15 December 2021

Our Ref: R/2020/14/A and R/2016/20/D
File No: 2021/530190
Your Ref: SSD-9978934 and SSD 7684 MOD 1

Request for advice - Cockle Bay Park Redevelopment - Modification to Stage 1 (SSD 4684 MOD 1) and Stage 2 (SSD-9978934)

## Crescent Garden

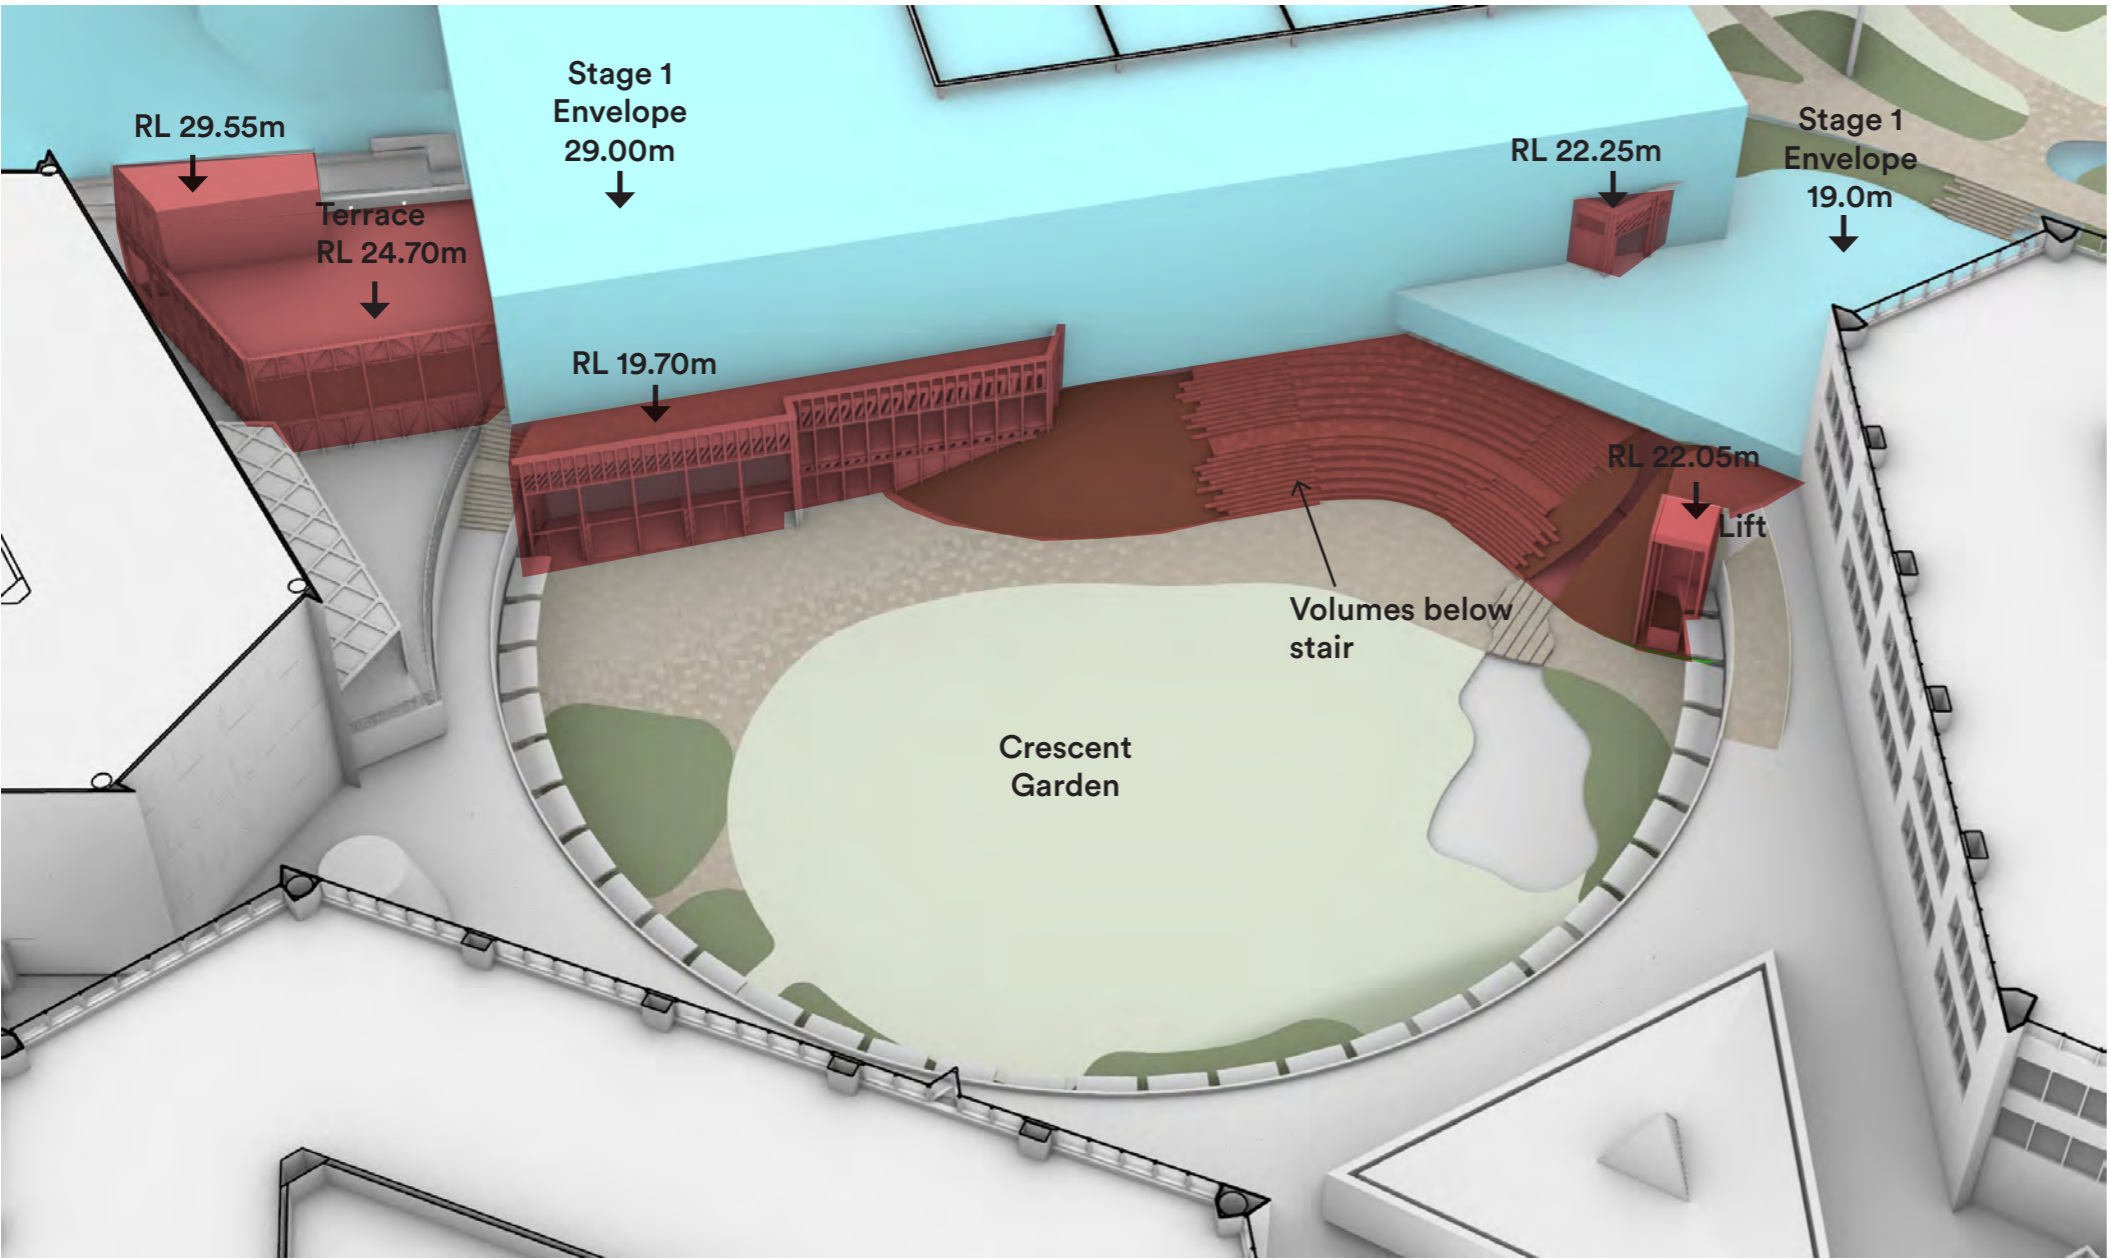
The existing Waratah Gardens are proposed to be demolished and replaced with the open lawn and edge planting of the Crescent Garden. This garden, in its current form, provides a landscaped oasis space for workers from the surrounding towers, and is an exemplar green roof within the City in terms of biodiversity, maintenance and longevity. It also provides a unique space within the CBD, and welcome respite in a dense, urbanised area. To remove this in its entirety seems heavy-handed and a significant loss, particularly if a space with such obviously successful function is to be replaced with one that does the opposite that provides little public seating, few small, intimate spaces, and greatly reduced biodiversity.

It is recommended that the applicant reconsider the retention of this garden in part, or alternatively, better integrate the design principles embodied in this successful roof garden. This should, at the least, represent increased diversity of planting and the inclusion of several seating spaces of various scales, in particular the smaller, more intimate scale that is otherwise missing in the proposed landscape proposal. The City considers that the proposed south-facing bleachers does not adequately replace the quality of the existing garden.

# Tower - Retail Pergolas

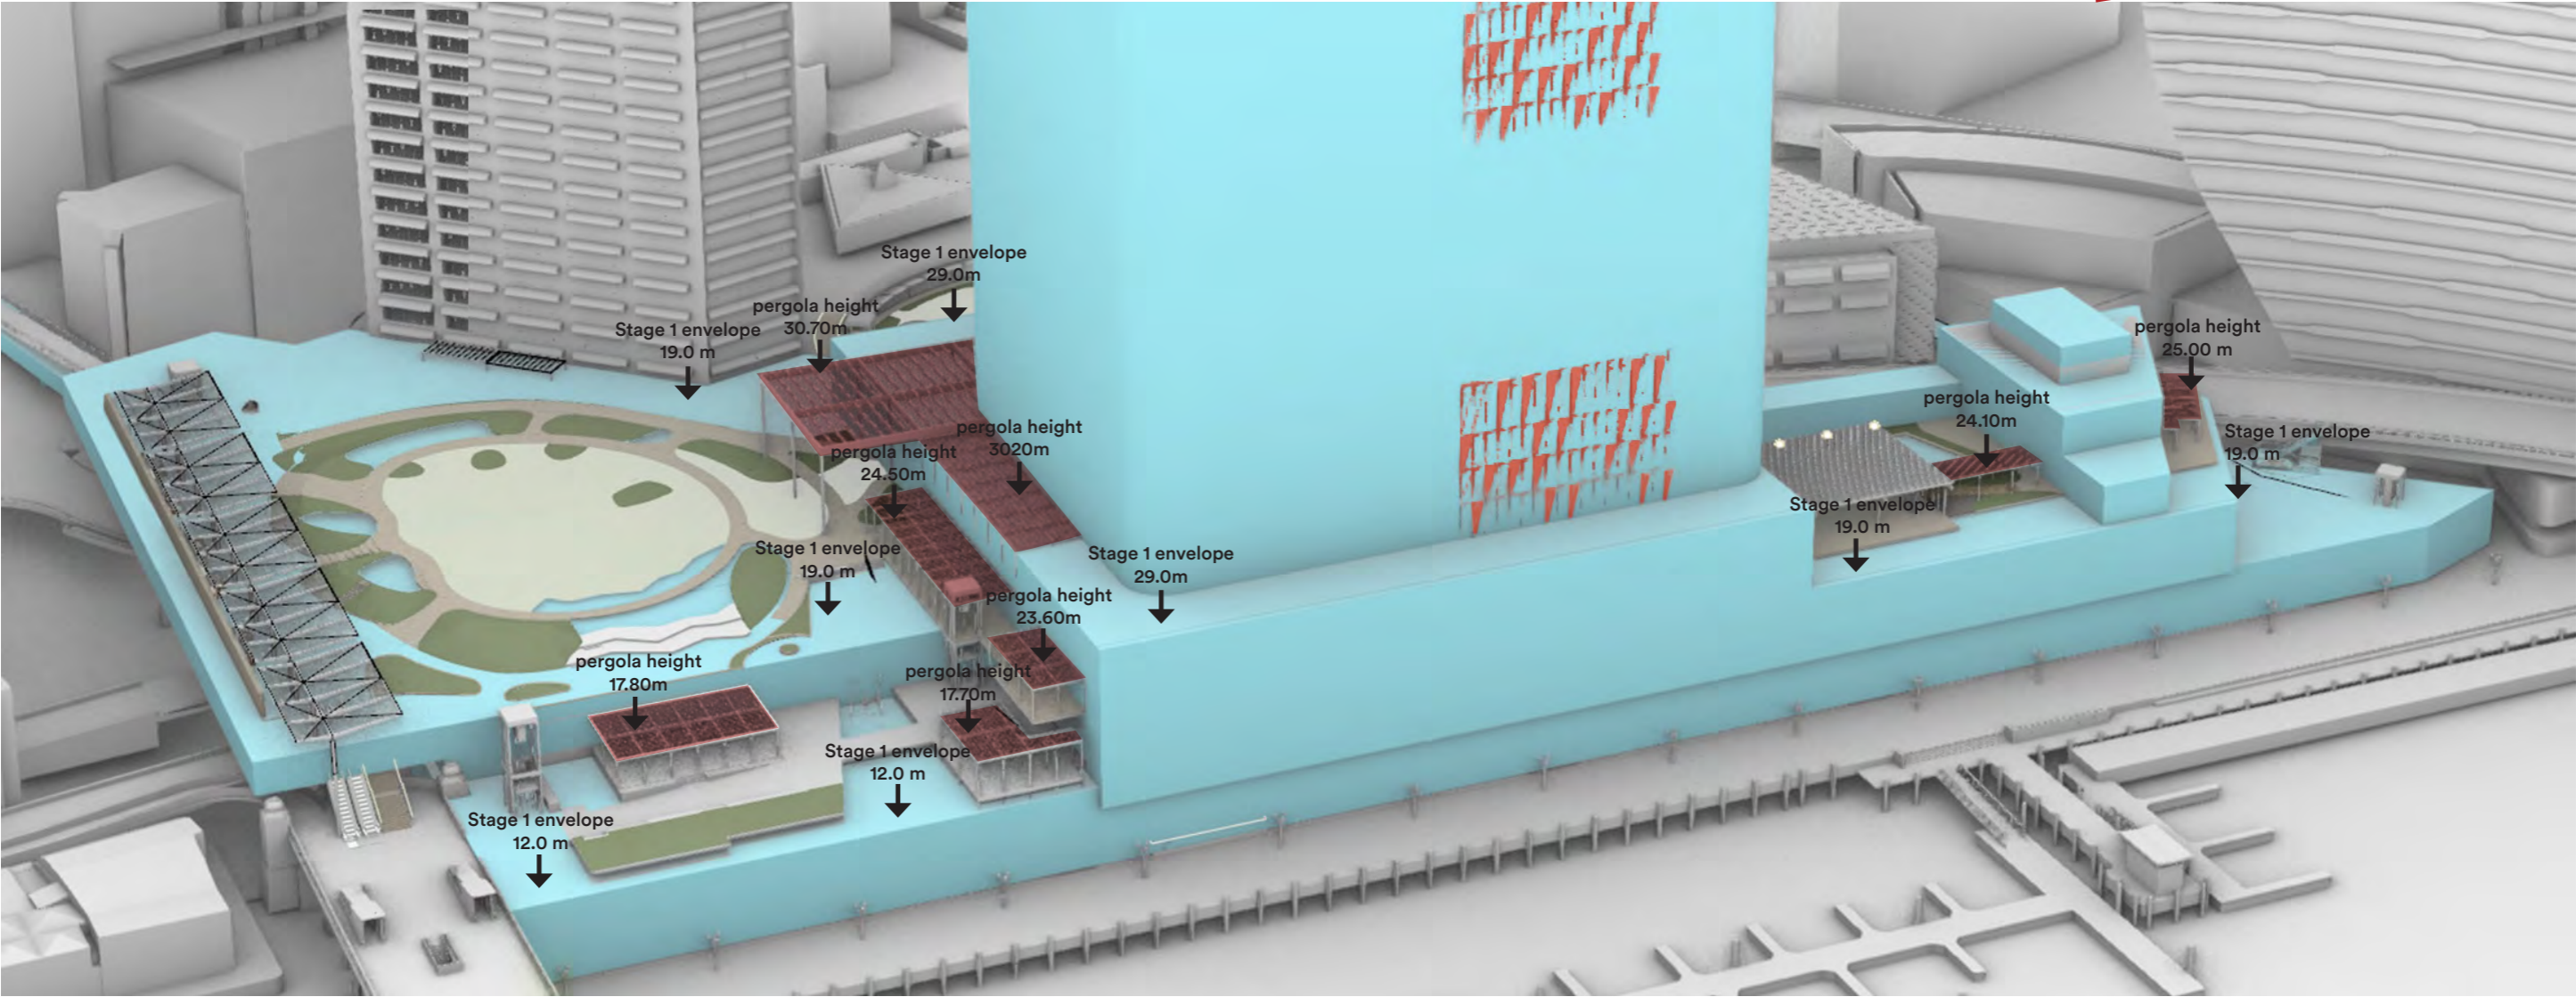
Four different types of pergolas have been included in the scheme, with varying levels of cover. Whilst these are likely to manage the major wind impacts of downwash from the proposed towers, the pergolas are not designed or located in conjunction with the landscape design. Rectilinear forms are imposed over an organic landscape design, with often little relation to the function of the space or the need for shelter. Notably, the pergola located within Park Plaza at the centre of the site is out of place. The sections provided in the landscape package illustrate the pergola has a height more than double the heights of other pergola structures

within the development. This does not appear to provide any purpose with regards to weather protection. Accordingly, the City recommends that this be deleted so that the public space can be open to the sky.

Additionally, the pergolas incorporate PV cells to service the development. The impact of the shade created by PVs on these pergolas should be interrogated against the planting design.
